CITY OF ALBUQUERQUE

December 26, 2024

Re: Carlisle and I-40
Traffic Impact Study (H16D047)
Engineer's Stamp 11-22-24
Via email BrianHoran@GallowayUS.com

PARKING STUDY V3

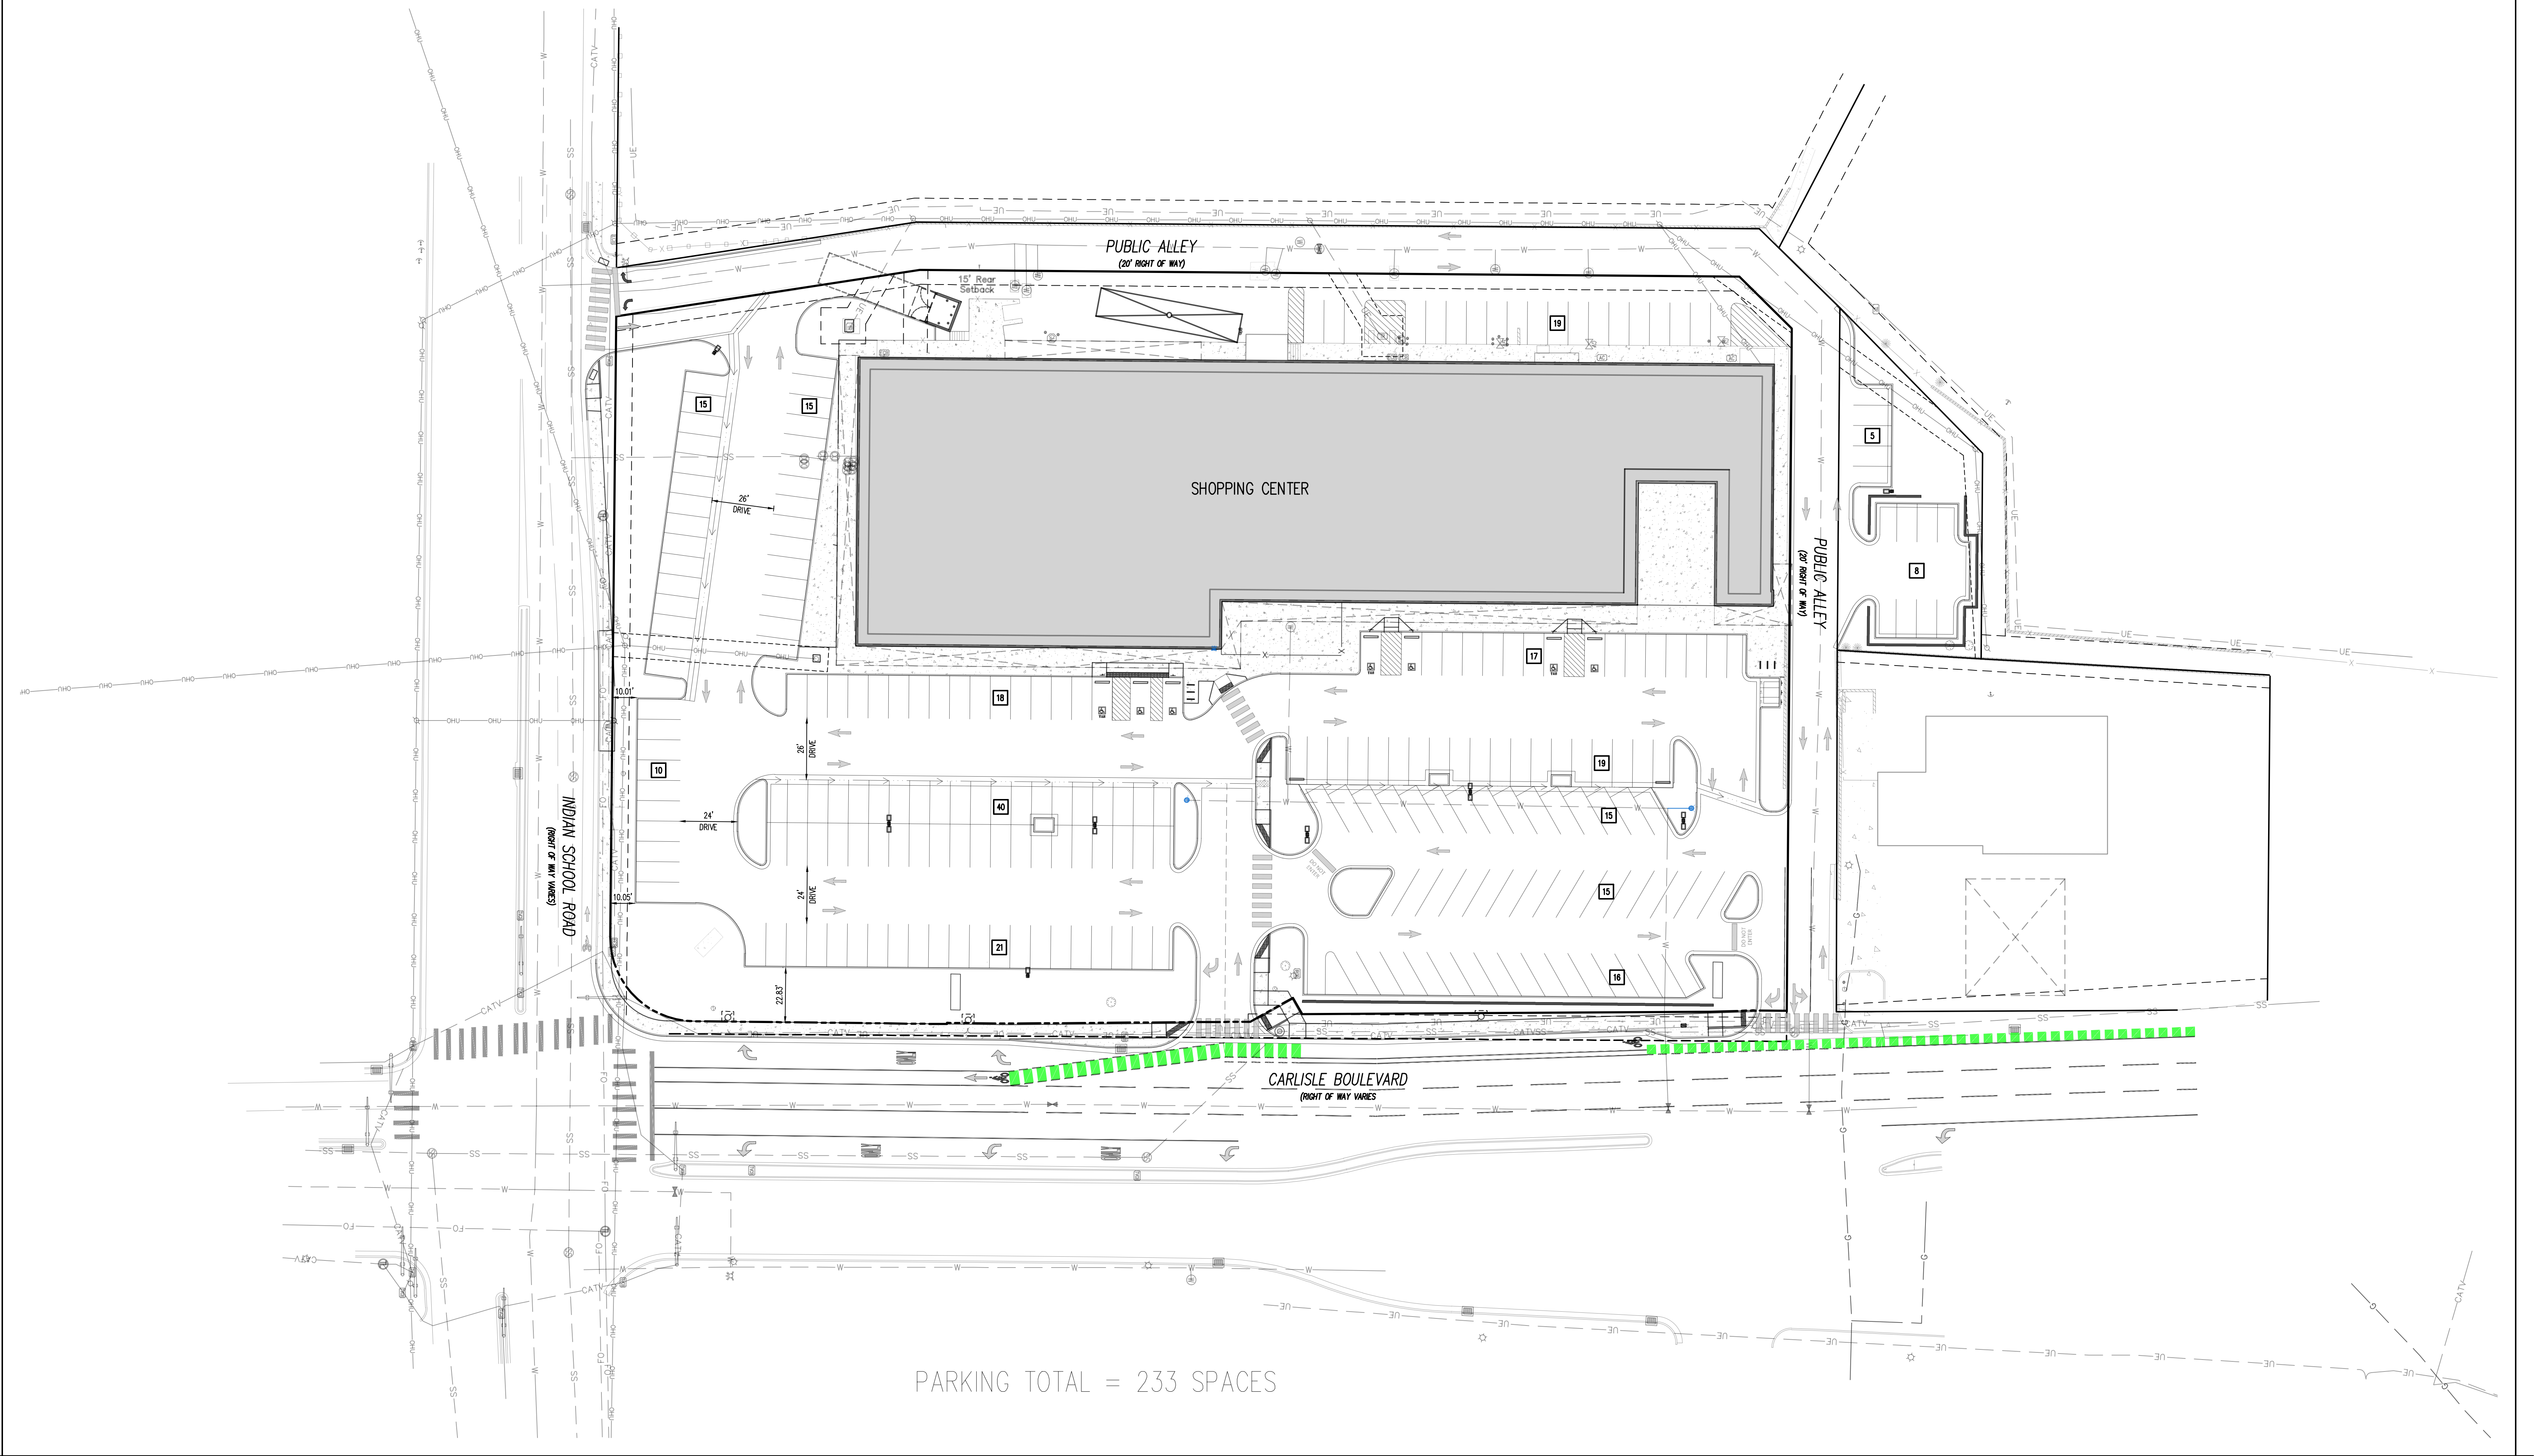
The Site Plan/Parking Study dated 12-11-24, replaces Figure 1-2 Site Plan in the Study as the Developer elected to remove the drive-thru business.
